**PRELIMINARY DRAINAGE REPORT
FLYING HORSE NORTH PRELIMINARY PLAN AND
FINAL DRAINAGE REPORT FOR FLYING HORSE NORTH FILING NO. 1**

CCES COMMENT RESPONSES

BASIN SUMMARY - DEVELOPED CONDITIONS

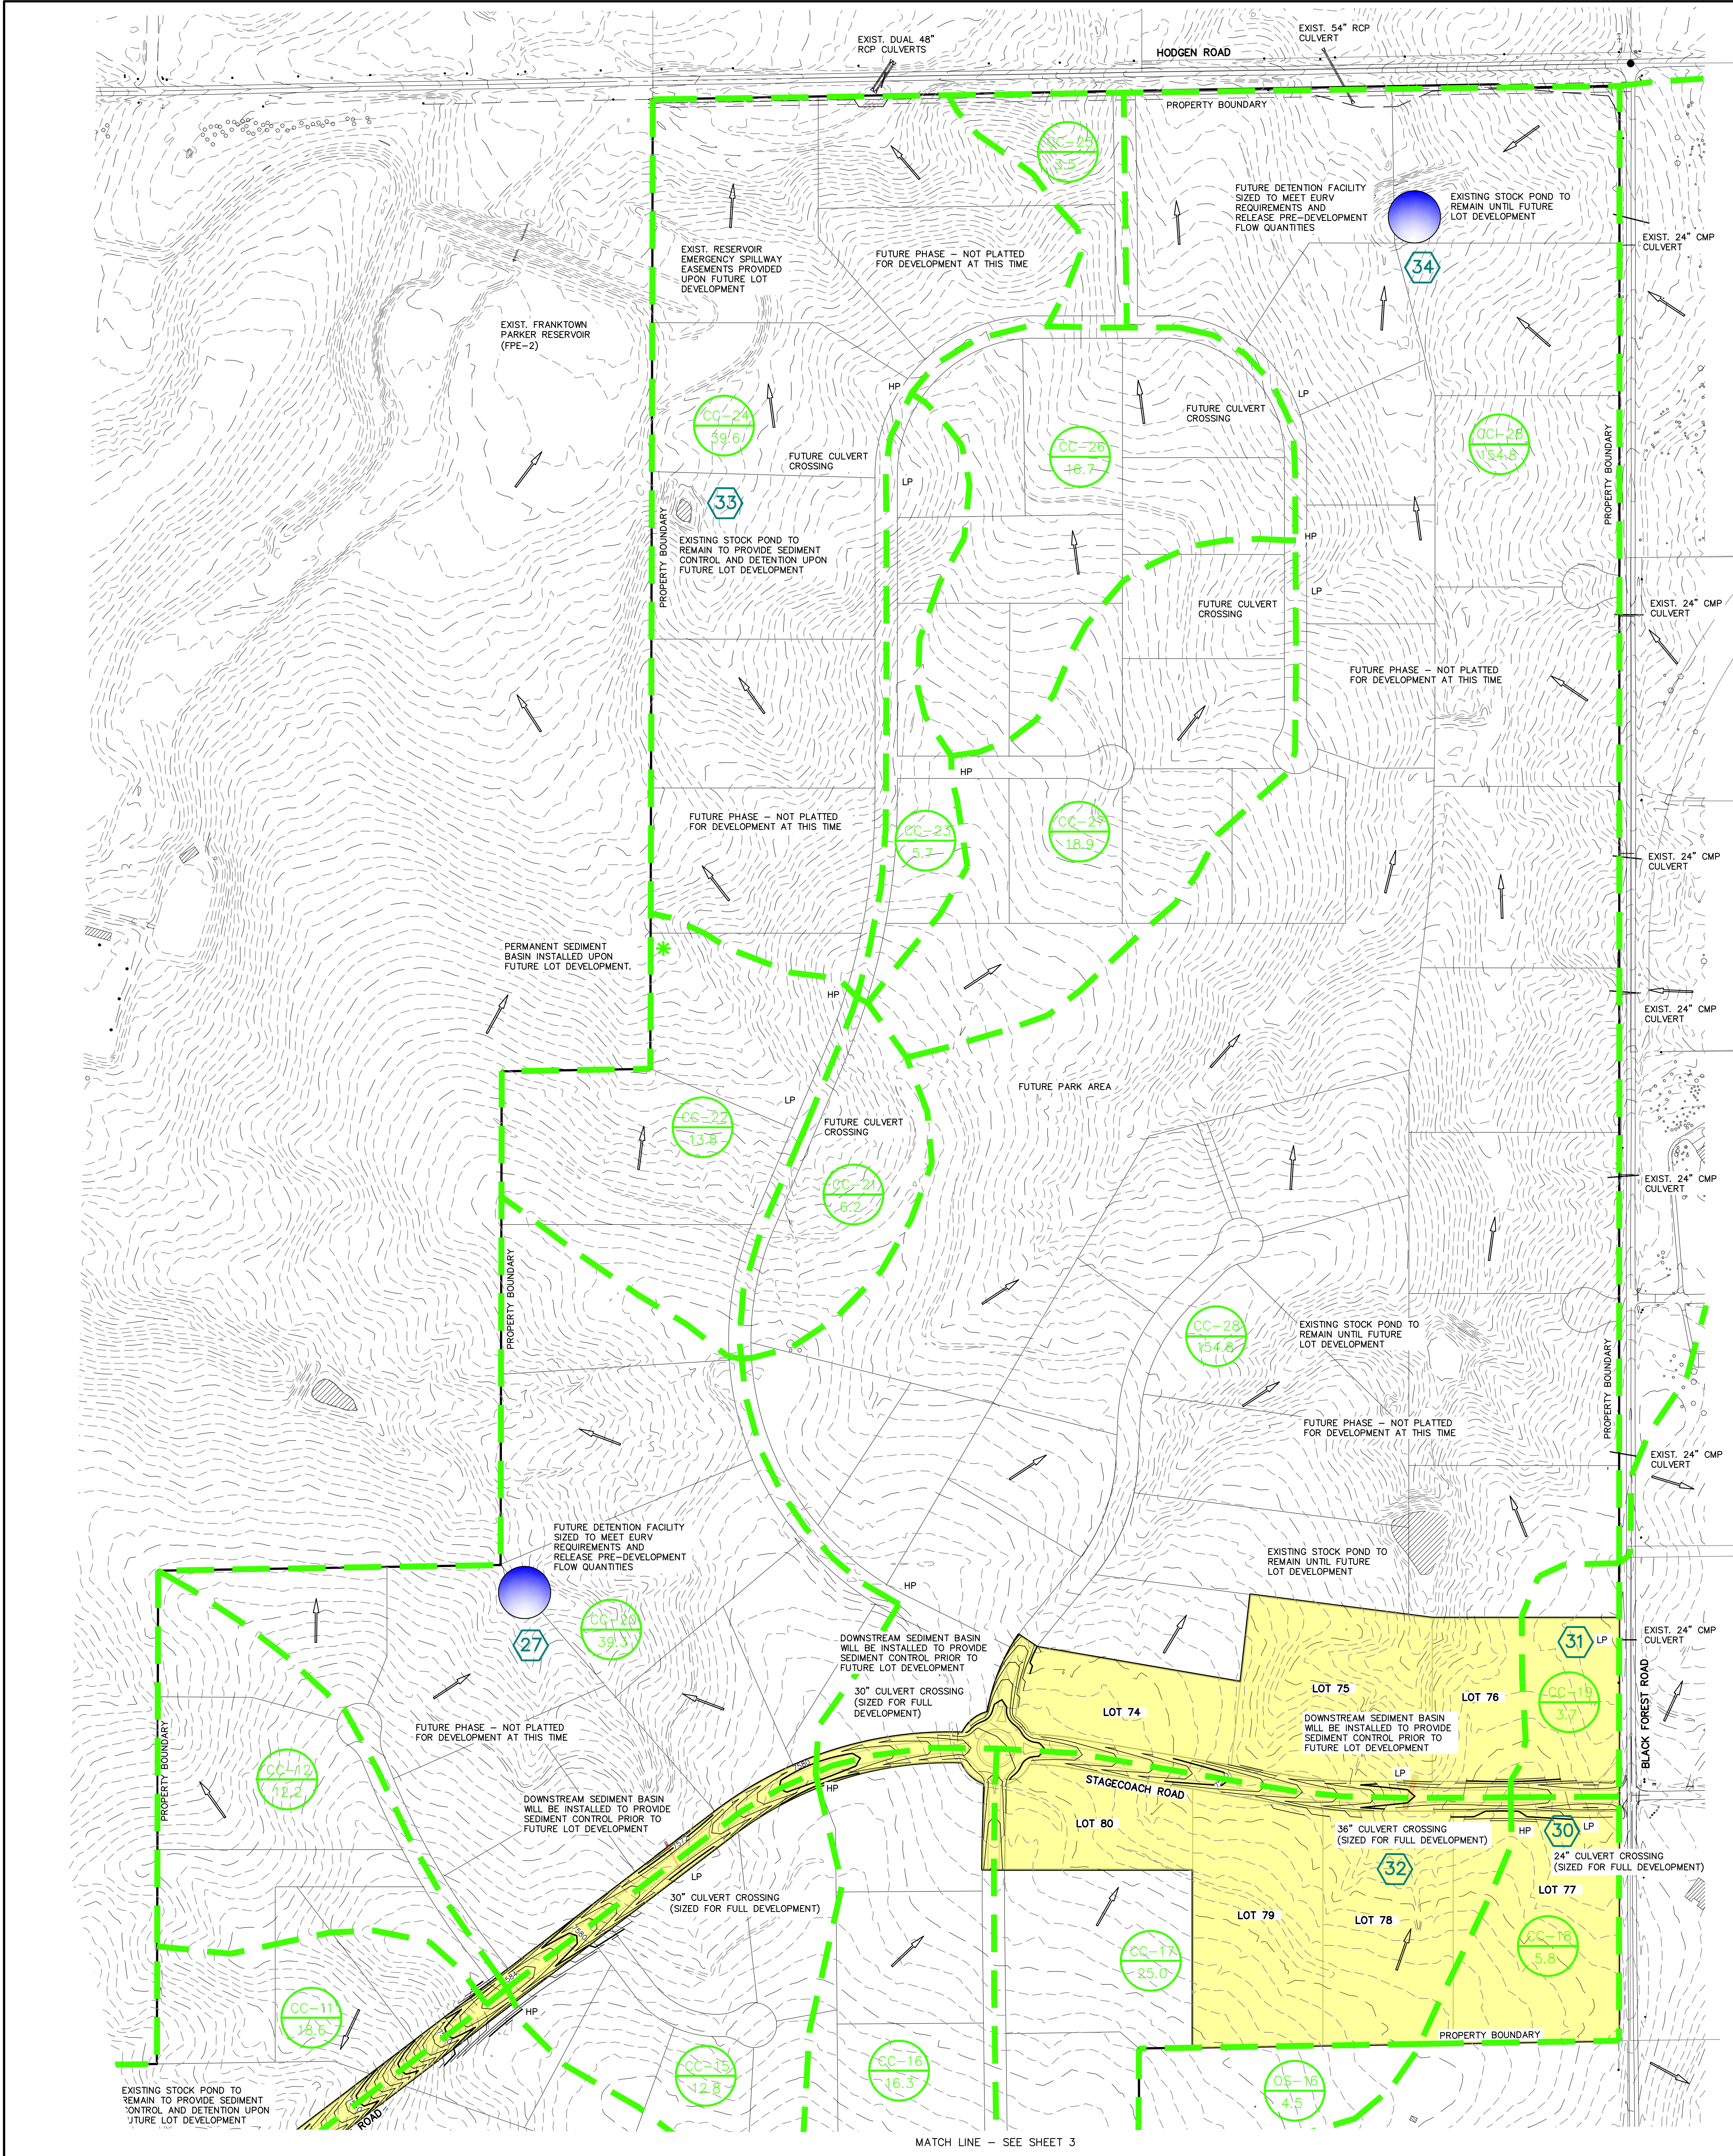
Include an existing drainage map and
provide the narrative for the sub-basin

Elaborate on where this drains to. From the drainage map it seems to drain into the future detention facility at DP 19. If this is the case then identify that ponds DP18 and DP19 must be designed/analyzed as ponds in a series.

Identify and discuss the emergency overflow path for Pond 18. It appears that it would cross over residential lots and into Pond DP19

BS-2
updated on map

see additional text in report
